# Rezoning Transportation Analysis

Petition Number: #2022-029

## Revision Log:

Date	Description
07-24-2022	First Review (AO)
08-23-2022	Second Review (AO)

Skyline Townes
Rezoning Site Plan
 955 Seigle Avenue Charlotte, North Carolina

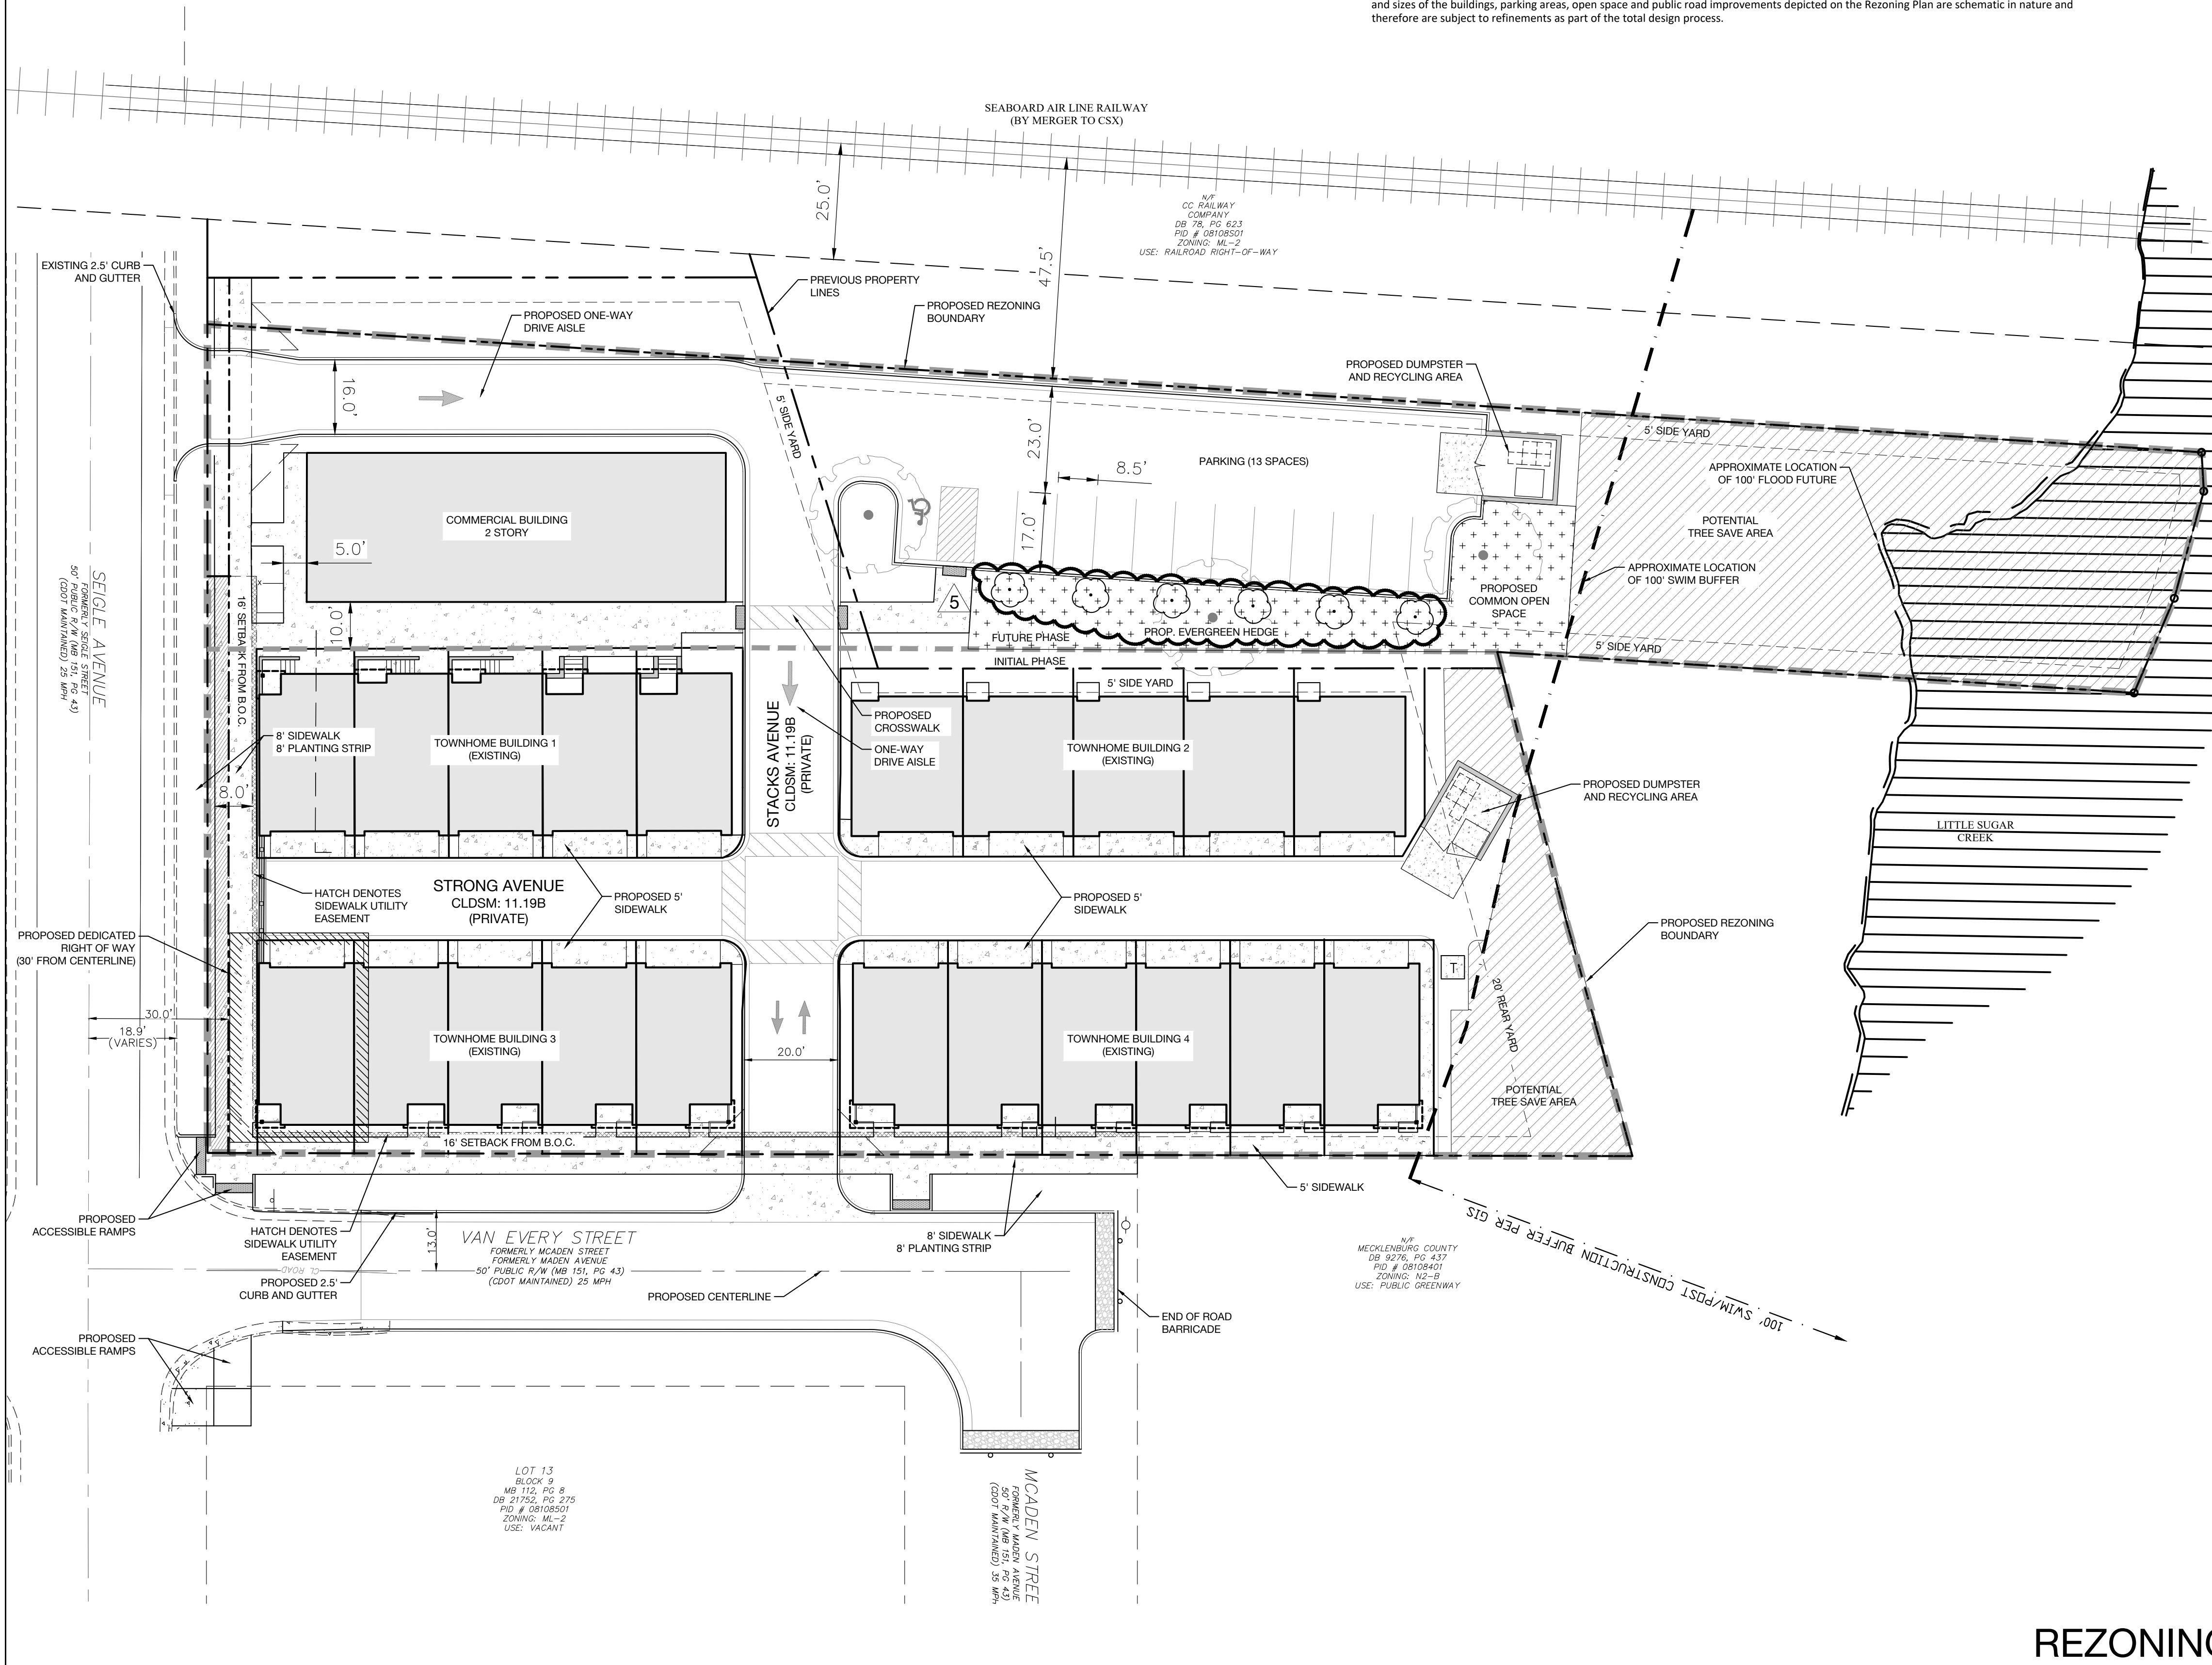
2. Revise site plan and conditional note(s) to list out proposed transportation and site improvements and their proposed phases (initial, future).
